## Fire Marshal Division

**Re: World Snow Daze  
5628 US 421 Hwy S.  
Lillington, NC 27546**

**Application Number BCOM1906-0001**

FLOOR PLAN
 SCALE: 1/4" = 1'-0"

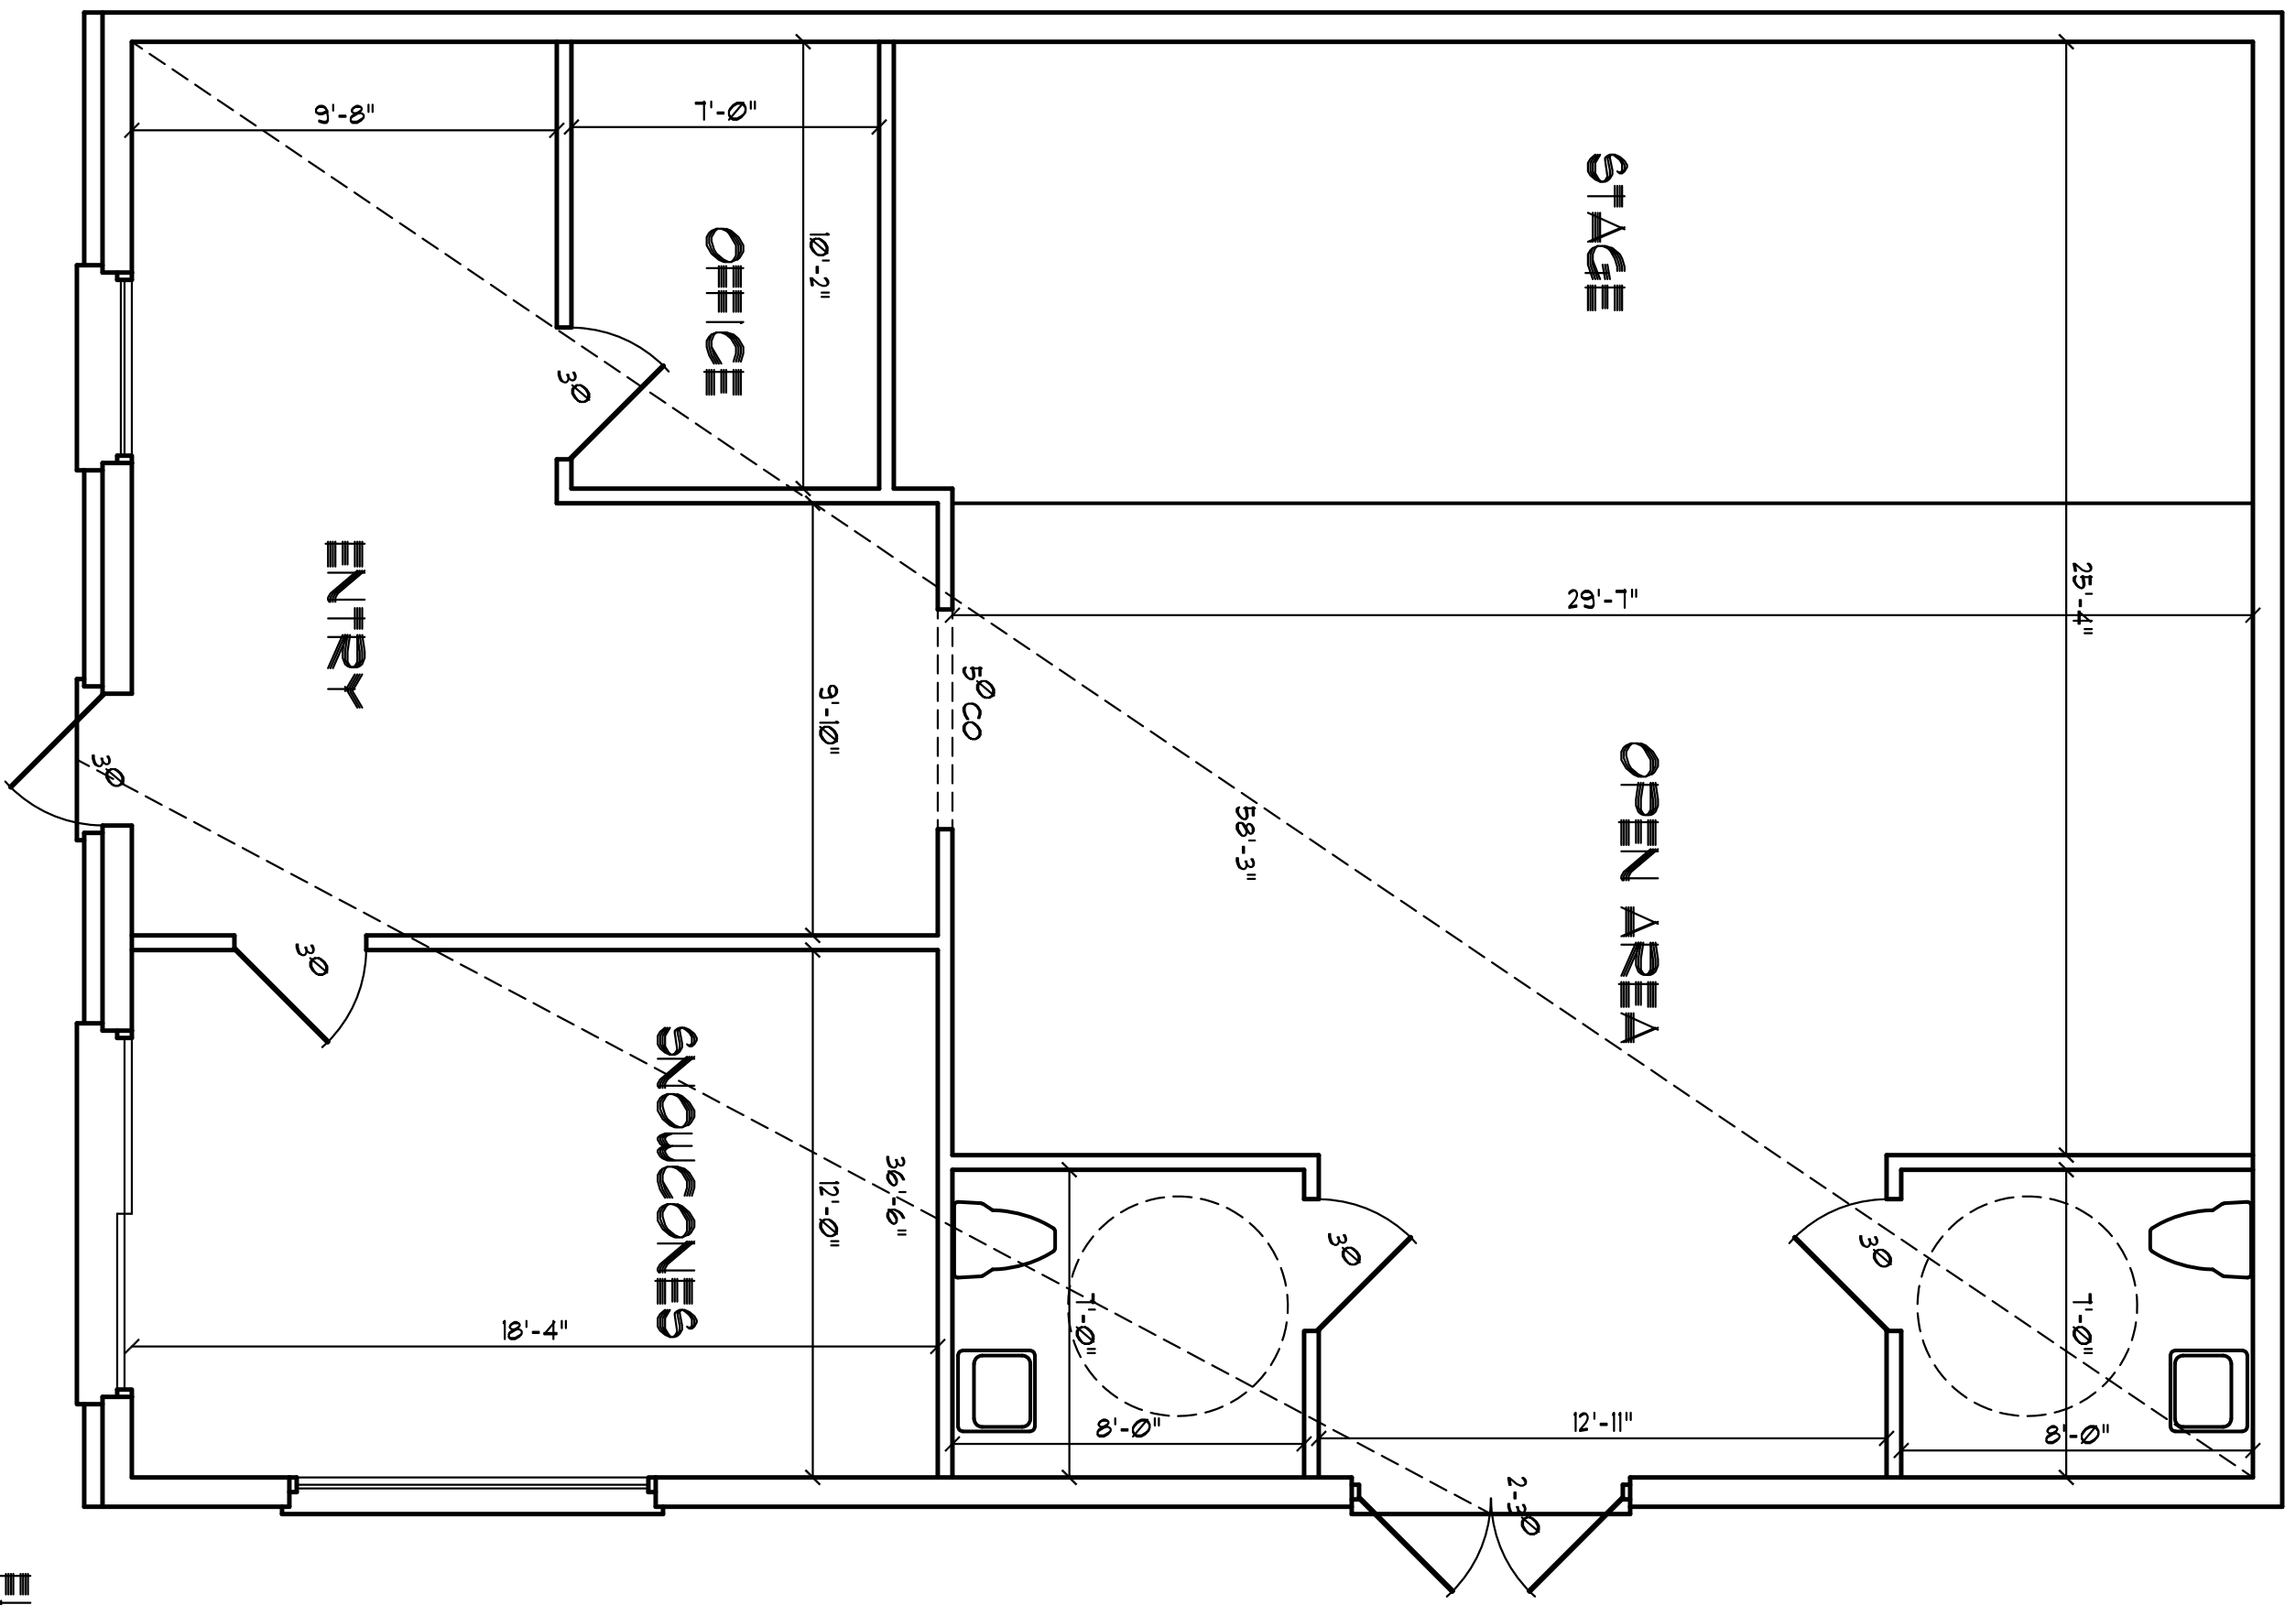
- A Knox Box is required to be installed on the building.
- The physical address numbers shall be mounted on the building. They should be a minimum 6" in height and visible from the roadway.
- The fire extinguishers are required to be properly mounted and tagged by a fire extinguisher company.
- A Fire and Life Safety Plan should be added to the plans to designate existing and proposed features.
- **A fire final inspection is required. Call 910-984-4003 to schedule.**
